CITY OF ALBUQUERQUE

December 9, 2015

**RE: Gonzales Residence Lot 11 Block 10 Unit 22 Volcano Cliffs
6308 Petirrojo NW
Grading and Drainage Plan
Engineers Stamp Date 12/7/15 (D10D0003F11)**

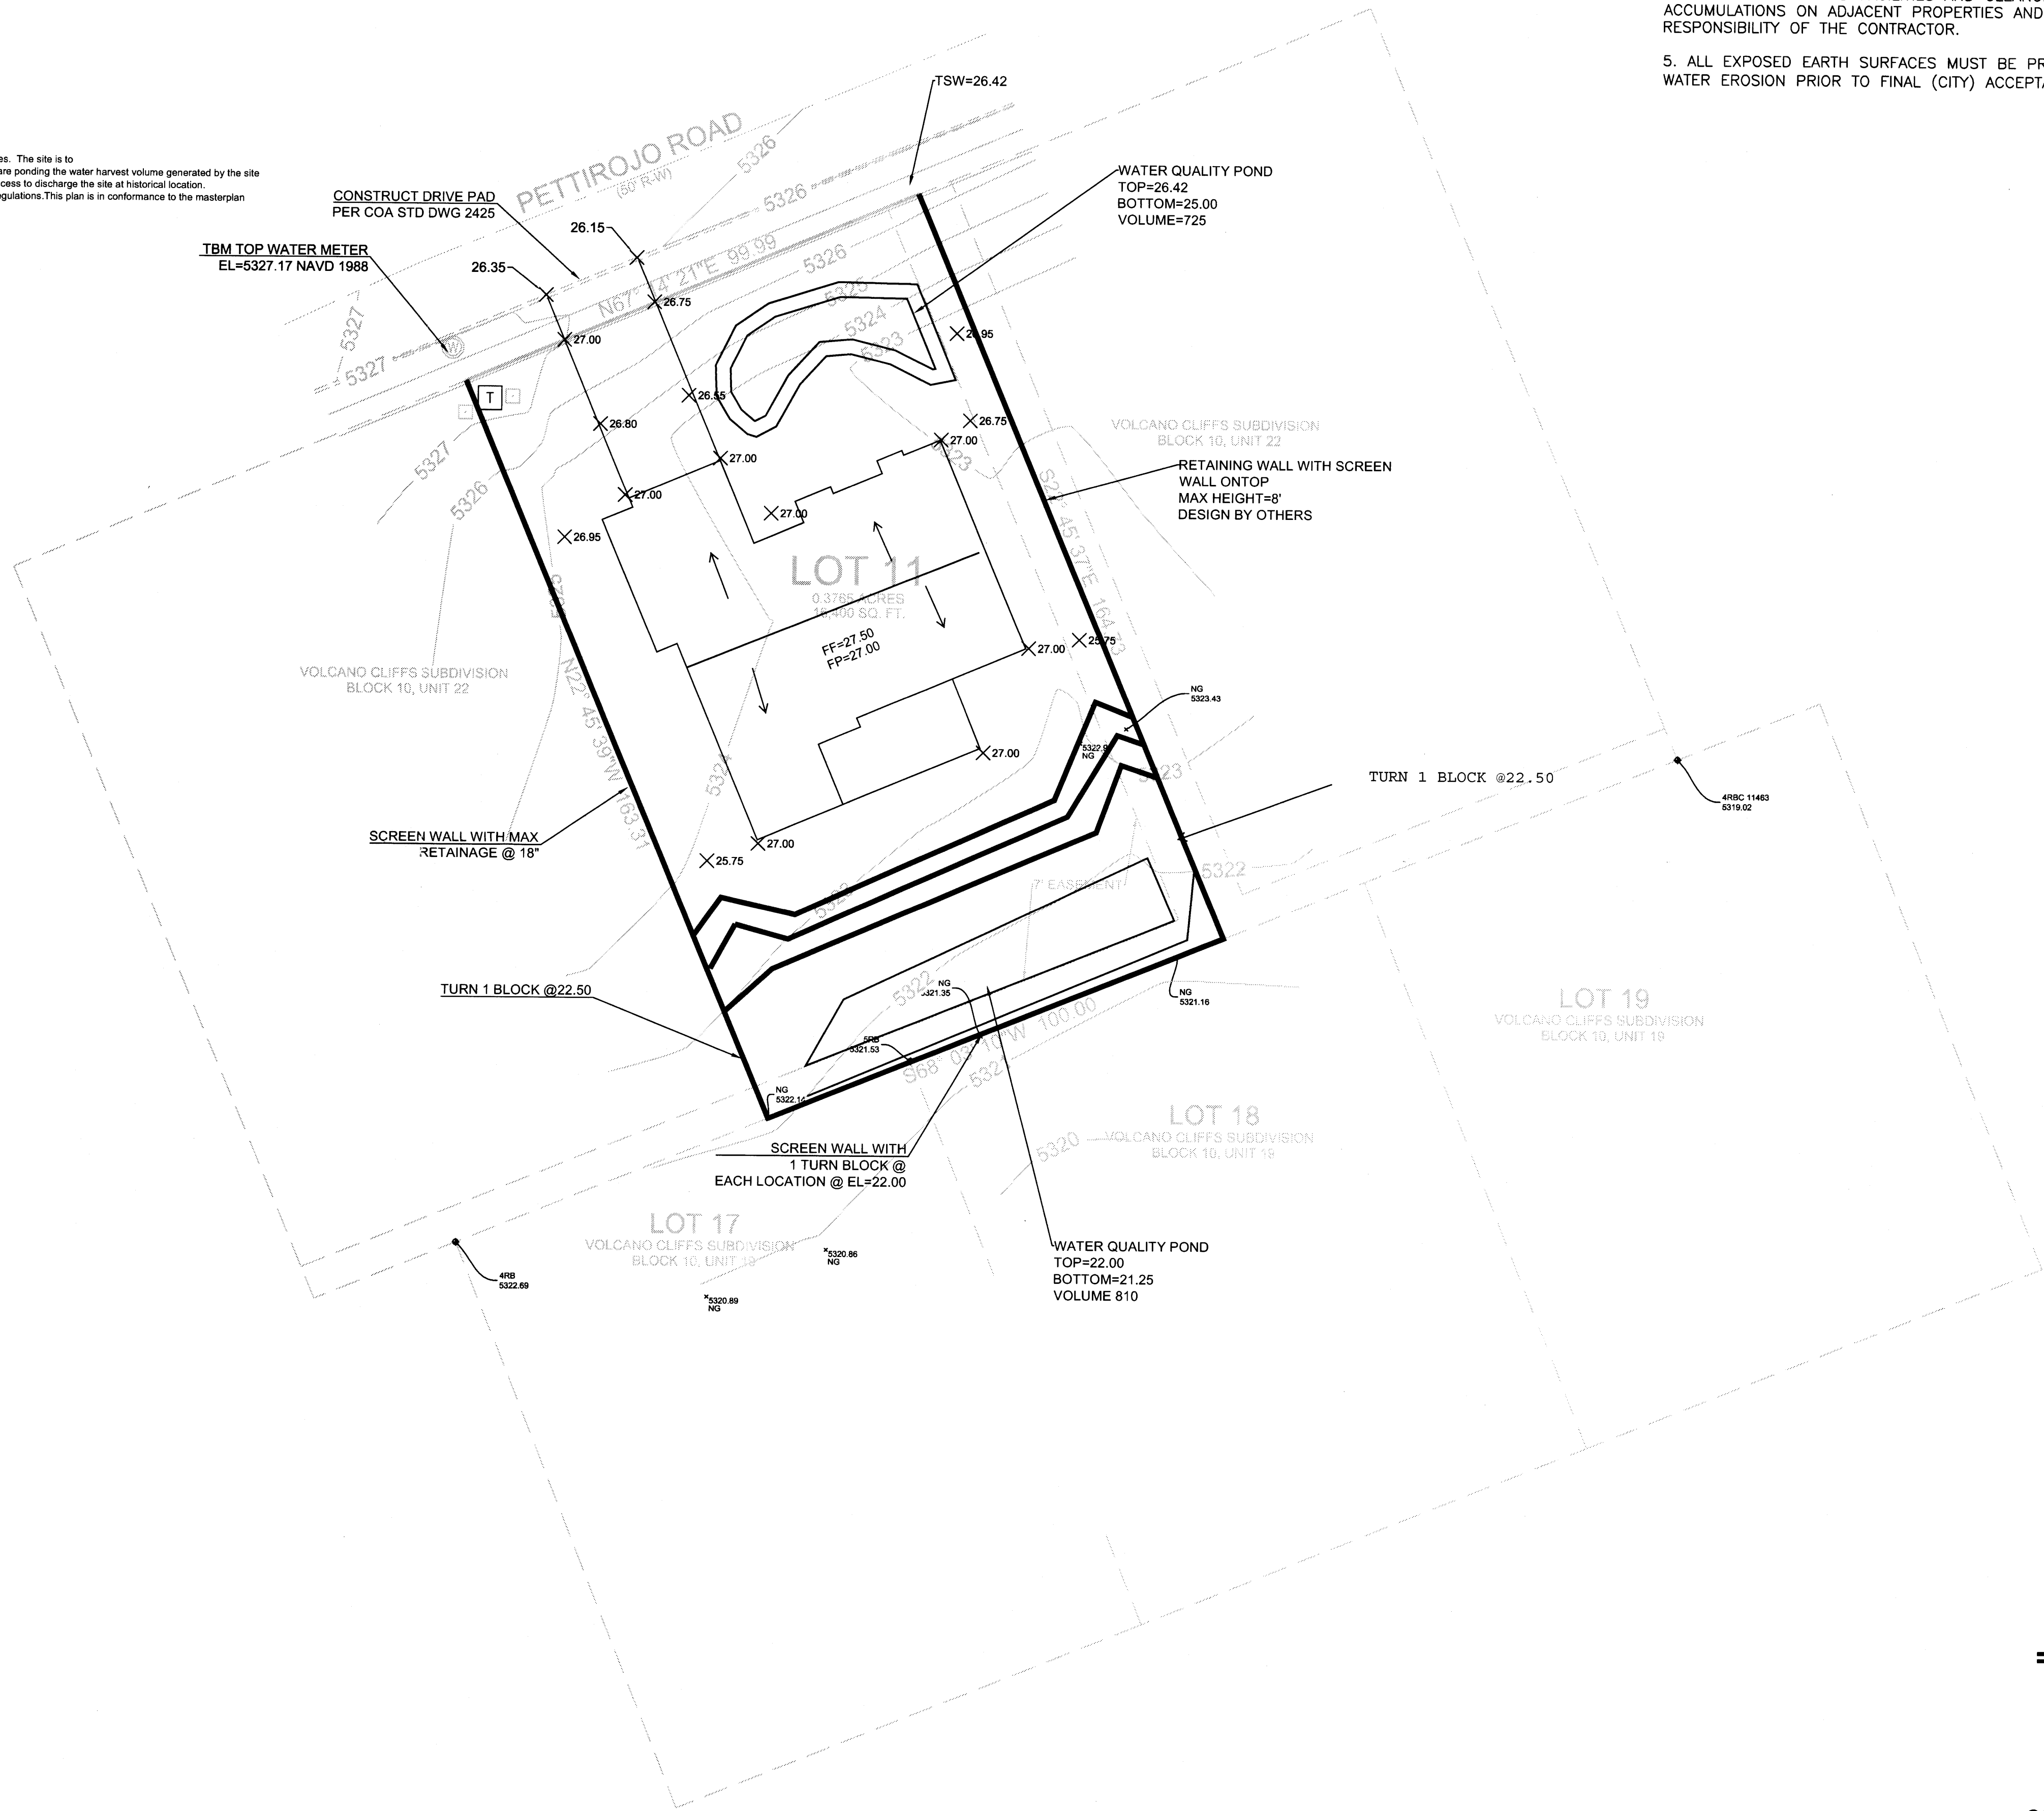
- This lot drains to two different ponds, the front half flows to pond 8 and the back half flows to pond 9, provide a site plan depicting this requirement.
- The turn blocks are located in the wrong fence line, the turn blocks should be placed in the east and west rear yard walls.
